Wise Engineering
3915 Old Fairground Rd.
Angier, NC 27501
(919)894-2203

Subject: 87 E Dooley St, Coats, NC 27521

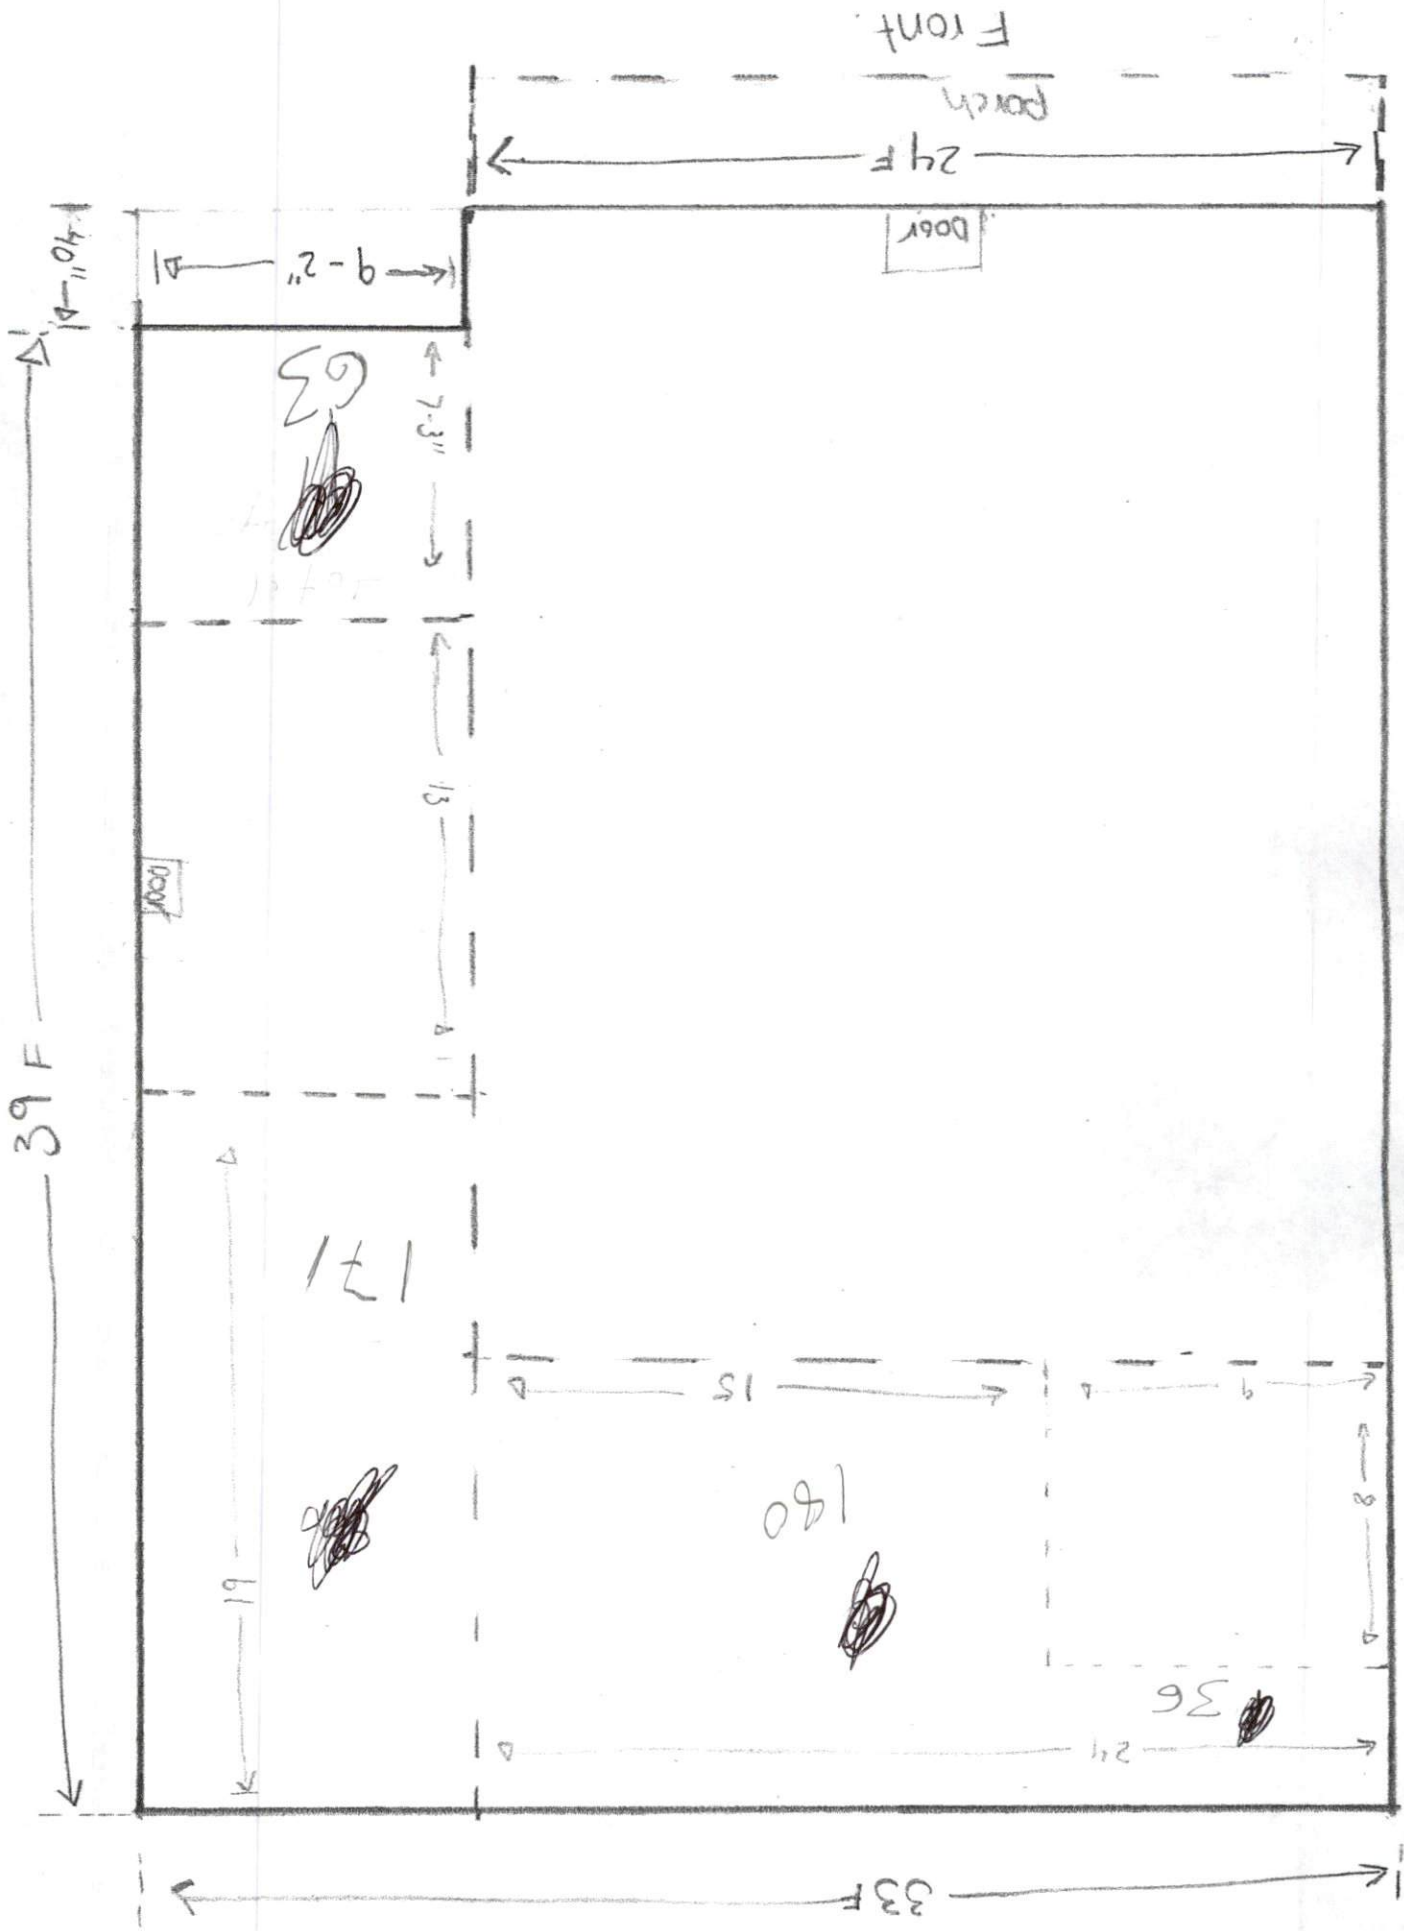
1. The window and door openings on the front of the home do not have headers to support the loads from above. WE recommends installing a (2)2x8 header supported by one jack stud and one king stud on each end over each of the window and door openings.

3. The header for the side of the front porch extends into the wall framing, however, there are not any jack studs to support the load of the header. WE recommends installing two jack studs under the header to support the anticipated loading conditions.
